TRAFFIC IMPACT STUDY

Trinity Ranch

El Paso County, Colorado

PCD File No. CS252

FIGURE 5

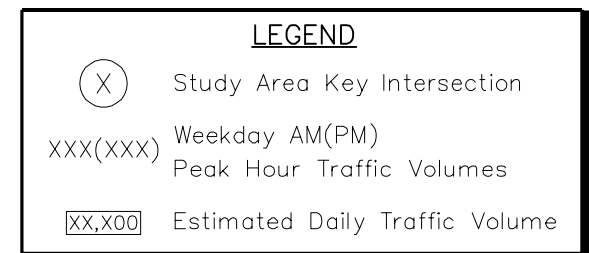
Include this intersection

Revised.

FIGURE 6

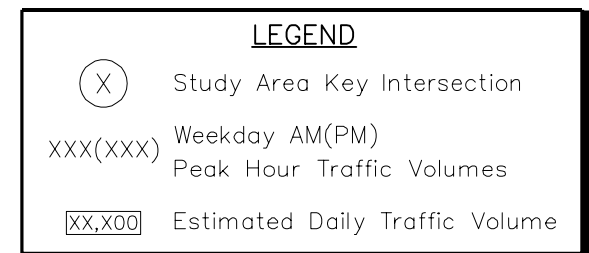
Include this intersection

Revised.

FIGURE 8

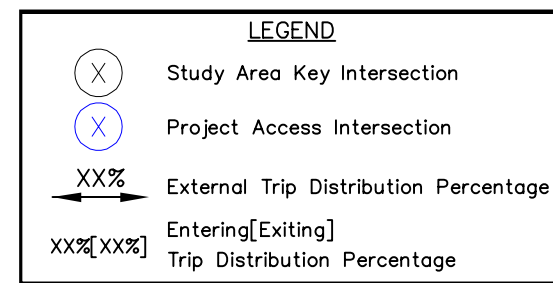
Include this intersection

Revised.

FIGURE 12

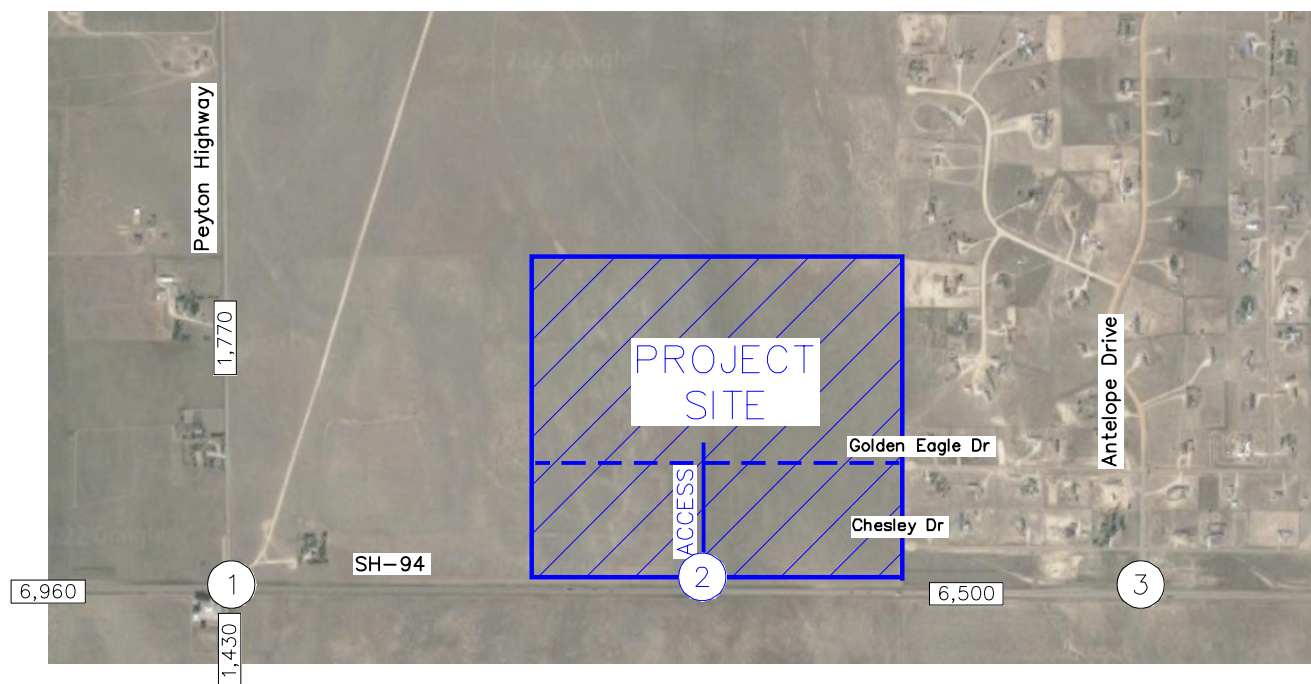
Include this intersection

Revised.

FIGURE 15

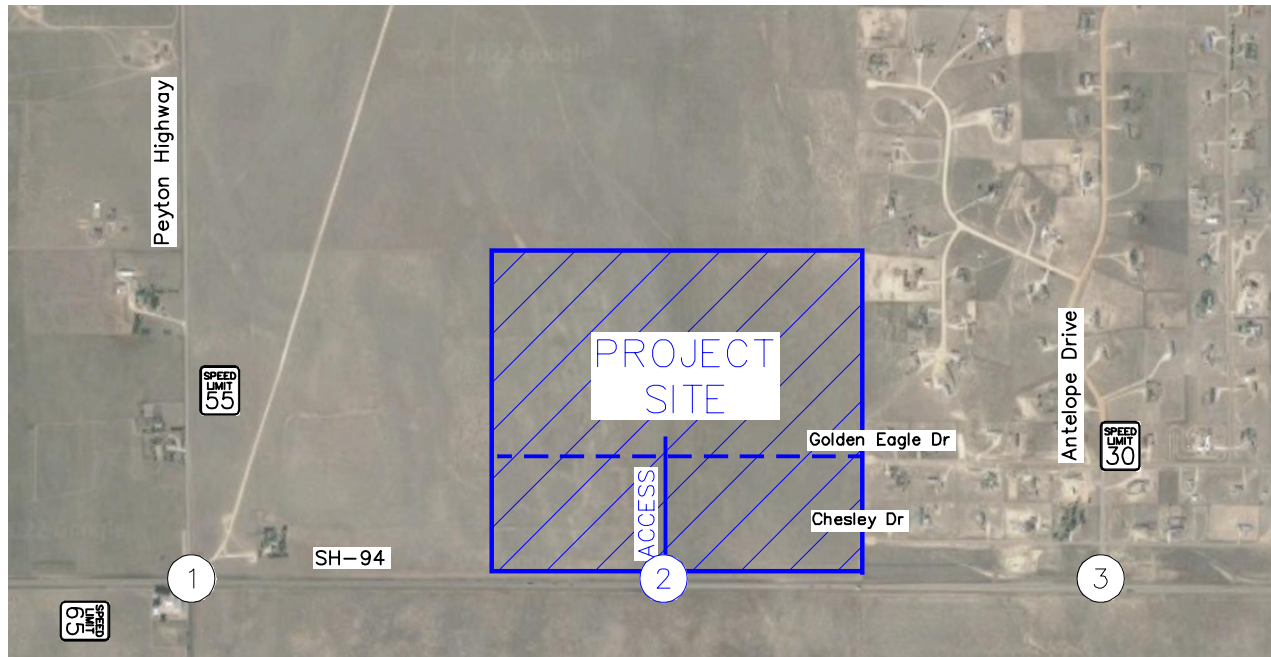
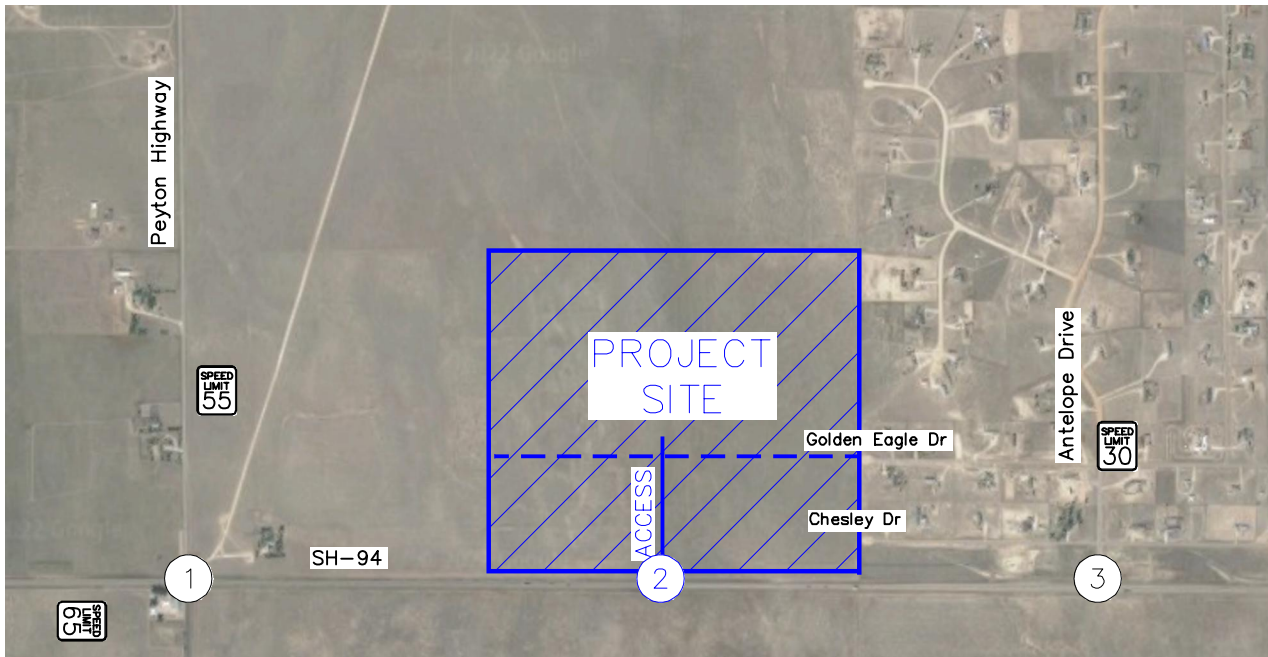
Be sure to include this intersection as this is the "main" access for Filing 1. Typical comment for following Figures as well.

2029 Rec Geo Figure has been added while SH-94/Antelope has been added to 2030 buildout and 2050 long-term recommended geometry figures.

Map 9: Existing and 2040 Traffic Volumes

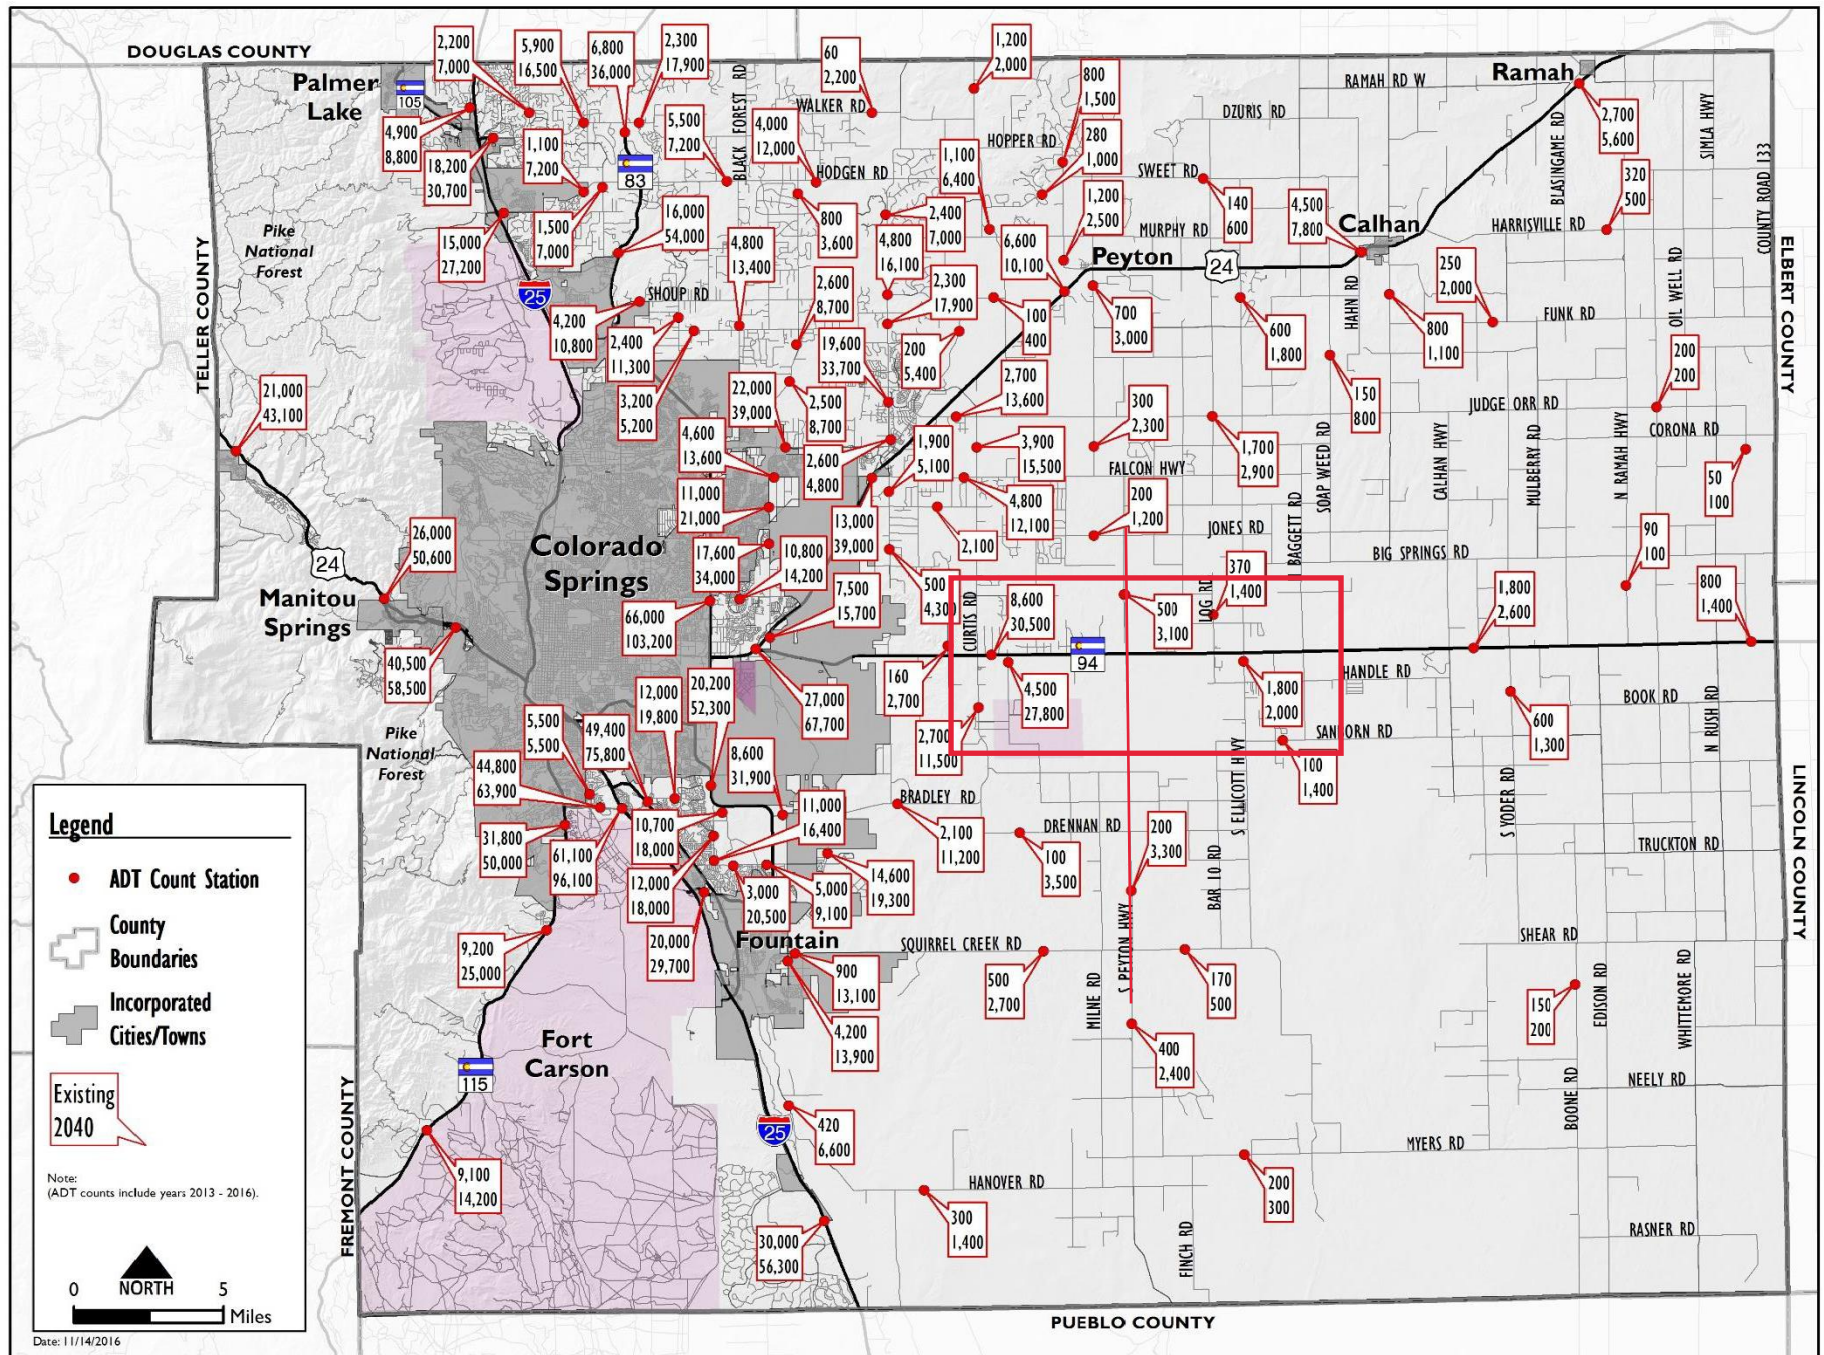
Update to maps from 2024
MTCP report

The 2024 MTCP maps have been added to the Appendix. However, it should be noted that the recently adopted 2024 Major Transportation Corridor Plan (MTCP) only provides wide ranges of ADT projections (i.e. 0 - 10,000 vehicles per day) and does not provide more refined ADT projections (i.e. 10,200 vpd); therefore, traffic volume growth projections cannot be calculated with the 2024 MTCP. As a result, the previous 2016 MTCP was utilized to determine the appropriate traffic volumes projections in the area.
